Address: 12 Coppin Hall Lane Mirfield WF14 0EL

Application number: 2024/93079	
What is the application for?:	Change of use and alterations to care home unit 2 to form 10 self-contained apar
Address of the site or building:	The Radcliffe, 444, Huddersfield Road, Mirfield, WF14 0EE
Postcode:	WF14 0EE

Type of comment: An objection	
Do you wish your comments to be published on the website anonymously?	No
<p>I strongly object to the planning permission with the below reasons:</p> <ul style="list-style-type: none">• The proximity of the proposed car park, especially the bays located directly beneath my rear window (the only fire exit from that part of the house), presents a serious and unacceptable source of continuous noise pollution. My partner works from home and requires a quiet environment, yet this plan will result in noise from car engines, slamming doors, car alarms, and conversations at all hours—mornings, evenings, and weekends. This will severely disrupt our work, sleep, and personal life.• With the care home at the back already, we currently experience and have witnessed members of the public, staff and doctors sitting in their cars with their engines running, the smell of

PROPOSED SITE LOCATION PLAN & CAR PARK LAYOUT PLAN SCALE 1:200 @ A1

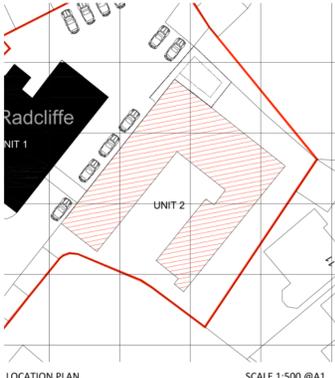
- The location of the bays directly under a only fire exit at the rear of our property raises serious safety concerns. We require this to be kept empty at all times in case of any emergency, if a vehicle is parked there, we have no way of escaping the property, as we have no back door, the window must be used.
